Your Ref
BE/104/11/
Our Ref
S/AR/2011/104
Date: 17/10/2011

Proposal: Erection of a detached single garage. Amendments to BE/51/08. (Re-submission following BE/57/11.)

Site: Land Adj. 37 The Croft Bognor Regis, PO21 5TH.
BE/104/11/

Proposed New Detached Single Garage
at Land Adjacent to 37 The Croft, Bognor Regis
for Mr R Lailey
Drawing PG04a July 2011 Scale 1:500 / 1:1250
Block Plan and Location Plan

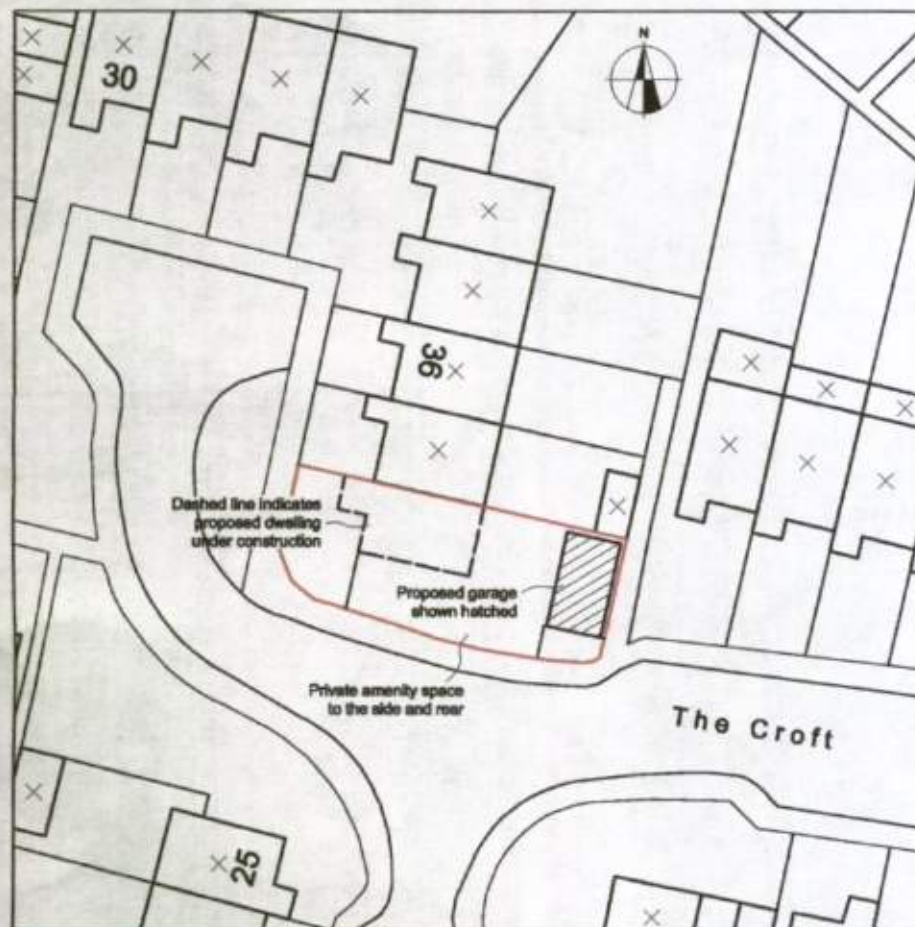
With regards to building close to the existing public surface water sewer:

1. No building/construction works within 2.0 metres of the public sewer is permitted, if found to be within 2.0 metres the sewer will have to be diverted or a rejection notice under the Building regulations will be issued.
2. Where within three metres, foundations to be taken down 150mm below the invert level which is approximately 1.2 metres in depth.
3. Location of 150mm diameter surface water sewer is to be confirmed on site before any works commence on site.
4. Care must be taken when working in the area of the public sewer pipeline so that no damage is caused, as any damage will be repaired at the applicant's expense.
